Ribble Valley Borough Council

DELEGATED ITEM FILE REPORT - APPROVED

Application No:	3/2014/1112
Site:	Cowley Brook Farm, Higher Road, Longridge, Preston, PR3 2YX
Development Proposed:	Single storey side extension, internal alterations and improvements to existing access (Resubmission of application 3/2014/0589).
Target:	4 th February 2015

PROPOSED SITE PLAN

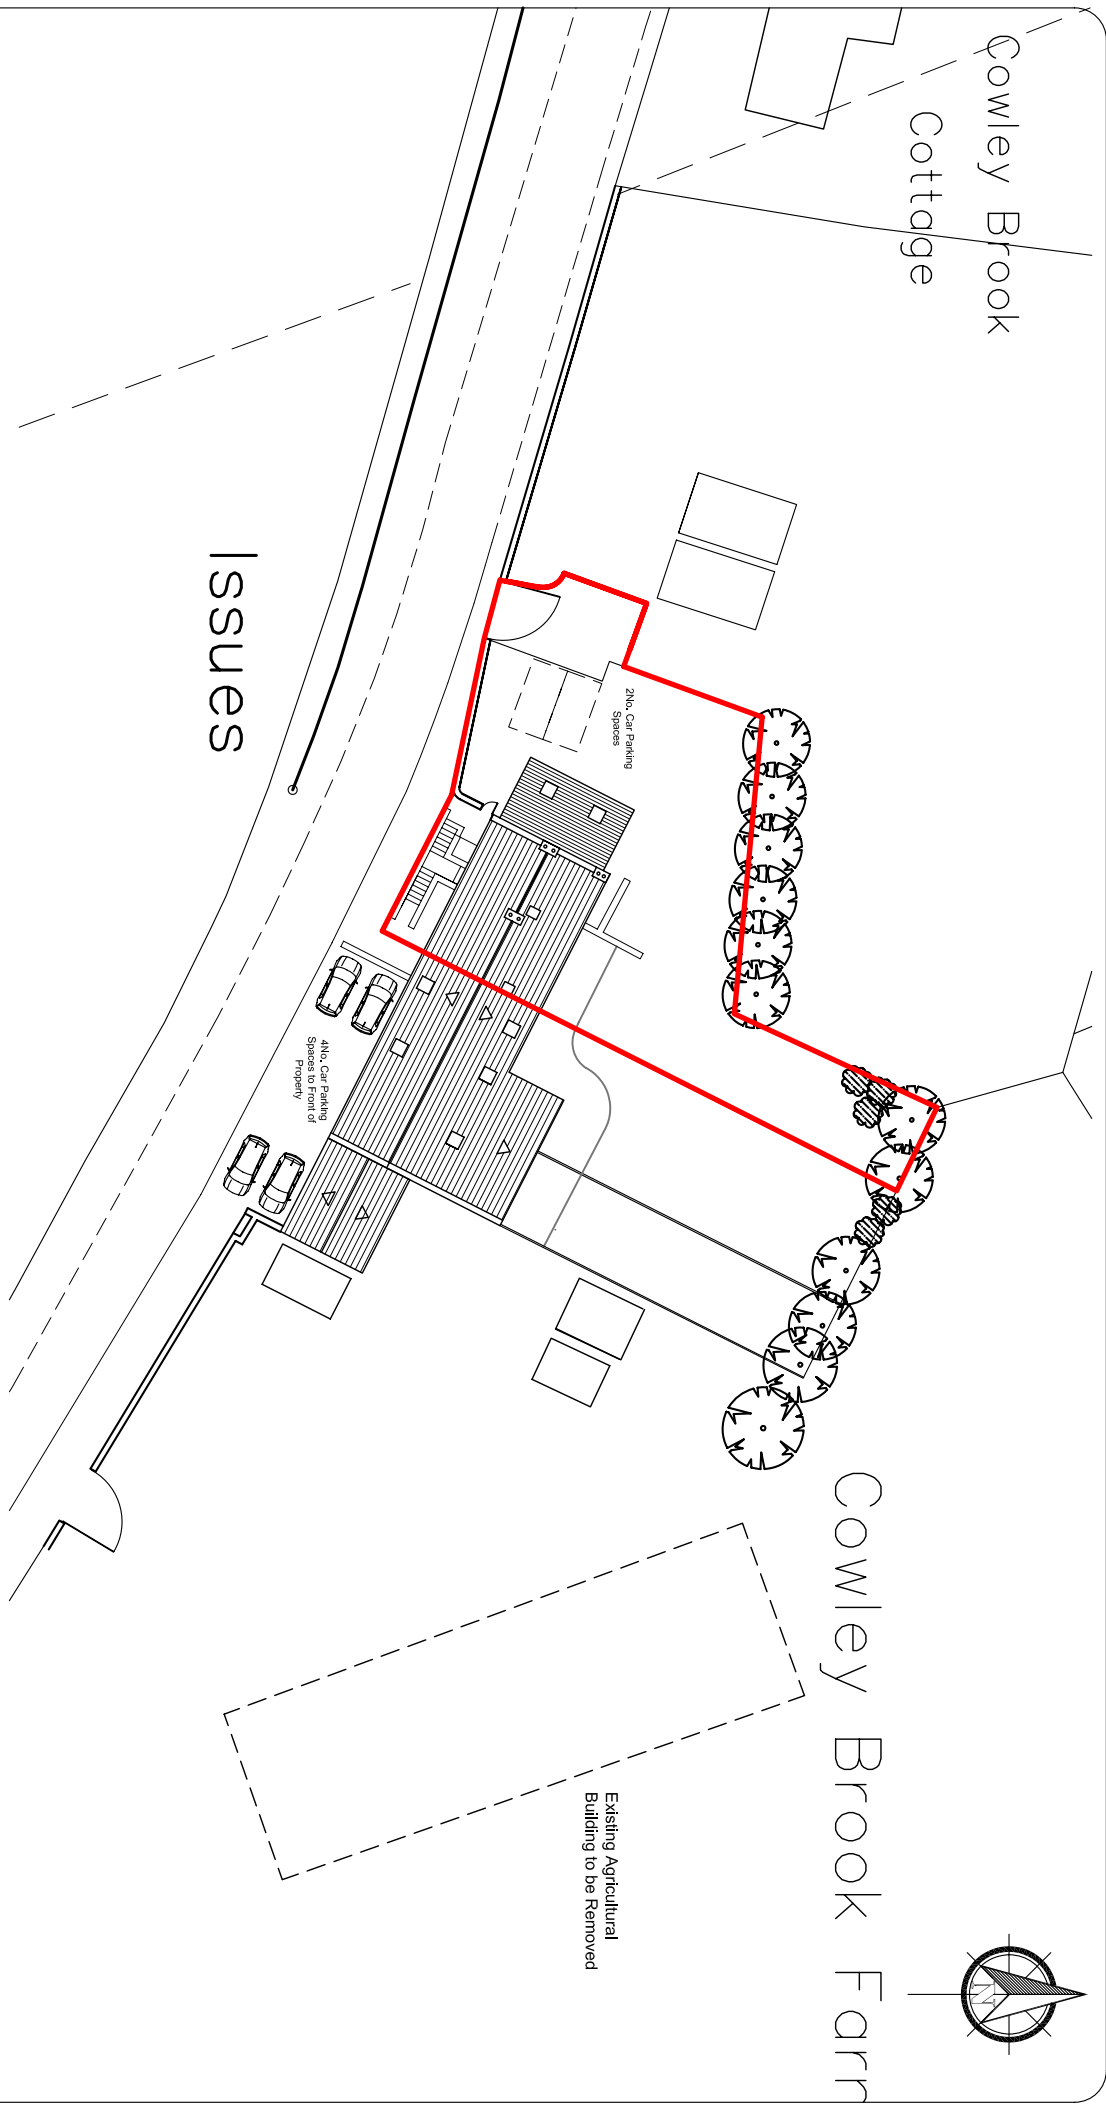
LCC Highways: Whilst I would raise no objection to the proposal, the proximity of the gate to the carriageway may result in problems with vehicles waiting on the carriageway whilst the gate is opened. It should therefore be removed or set back 5 metres into the site. Given the constraints of the site the latter option would, based on the current layout proposal, be impractical. Also there is no indication of the proposed surfacing material and I would therefore request that the following condition be attached to any permission that may be granted:-

No information has been provided regarding the nature of the improvements to the existing agricultural access and creation of two parking spaces within the existing garden area of the farmhouse. As such, a detailed assessment of its visual impact cannot be undertaken. However, the use of the opening for residential use would require a change of use of the land from agricultural to residential use (C3) and it is considered that the creation of a driveway across this plot of land would be detrimental to the rural character of the area and would cause significant harm to the landscape and character of the AONB contrary to policies EN2 and DME2 of the Core Strategy. Core Strategy Policy DMH5 is also relevant and states that *'curtilage extensions into the open countryside change the nature of the landscape'* and that *'curtilage extensions on sites wholly outside settlements will normally be refused'*. The current domestic curtilage is clearly defined by a post and rail timber fence. The formation of a driveway would result in the creation of a large area of domestic curtilage which, with its associated domestic paraphernalia, would lead to conditions which were detrimental to the visual amenities of the area contrary to Core Strategy Policy DMH5.

Thus, the applicant has sought to amend the scheme by providing a new access and gravel driveway entirely within the existing residential curtilage to the west of the application property. This would result in the removal of a number of trees that form part of the front boundary of the site and, whilst the initial arboricultural impact assessment indicates that these trees are of low quality or are unsuitable for retention, it is considered that cumulatively

their contribution to the visual appearance of the property and the immediate area are noteworthy. However, it is proposed to introduce new planting along the western extent of the site in order to reinforce the boundary and provide additional screening. Subject to the approval of appropriate hard and soft landscaping schemes, it is considered that the proposed development would not result in detrimental harm to the character of the host dwelling or the visual amenities of the AONB. As such, it is recommended that the application be approved.

Before the access is used for vehicular purposes, that part of the access extending from the highway boundary for a minimum distance of 5m into the site shall be appropriately paved in tarmacadam, concrete, block pavements, or other approved materials. Reason: To prevent loose surface material from being carried on to the public highway thus causing a potential source of danger to other road users.
